The Planning Inspectorate  
National Infrastructure Planning  
Temple Quay House  
2 The Square  
Bristol  
BS1 6PN  
United Kingdom

JNCC Reference: OIA-10357  
JNCC Registration ID Number: 20048439  
PINS Reference: EN010137  
Date: 7 August 2024

### **Mona Offshore Wind Project Development Consent Order Application – Environmental Statement and Management Plans – EN010137 – Written Representation**

Figure 1.2: Black-legged kittiwake expected collisions across months, contrasting a 0.9928 avoidance rate (NE) with a 0.9979 rate (Ozanlav-Harris et al).

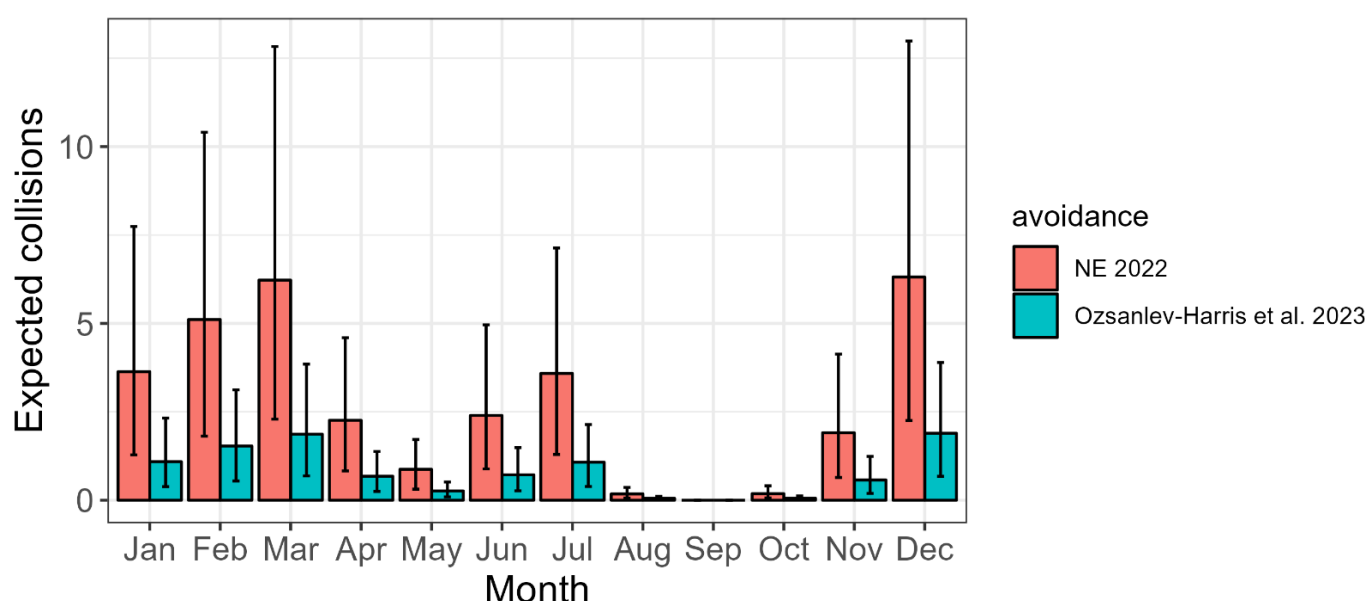
11. Similarly, the collision impacts on black-legged kittiwake has errors in:
  - Incorrect seasonal collision mortality estimates
  - Not presenting the full range of displacement/mortality within the displacement matrix

12. We illustrate this point in the two tables below with an example of the compounded differences in parameters used at different stages, for black-legged kittiwake qualifying feature of Rathlin Island SPA. The differences between JNCC's recommended approach (Table 1) and that taken by the Applicant (Table 2) are in the seasonal definitions, the displacement and mortality rates, the breeding season age class apportioning, and the non-breeding season age class apportioning, which ultimately results in very different seasonal and annual apportioned adult mortalities. It is therefore difficult to know whether this would result in impacts greater than 1% baseline mortality for any feature of any SPA and hence whether an SPA feature should have been taken through to Population Viability Analysis (PVA). On the basis of this, we do not currently consider that a sound conclusion of no AEOSI can be made. In addition, updated outputs should be provided in updated application documentation (ES, HRA
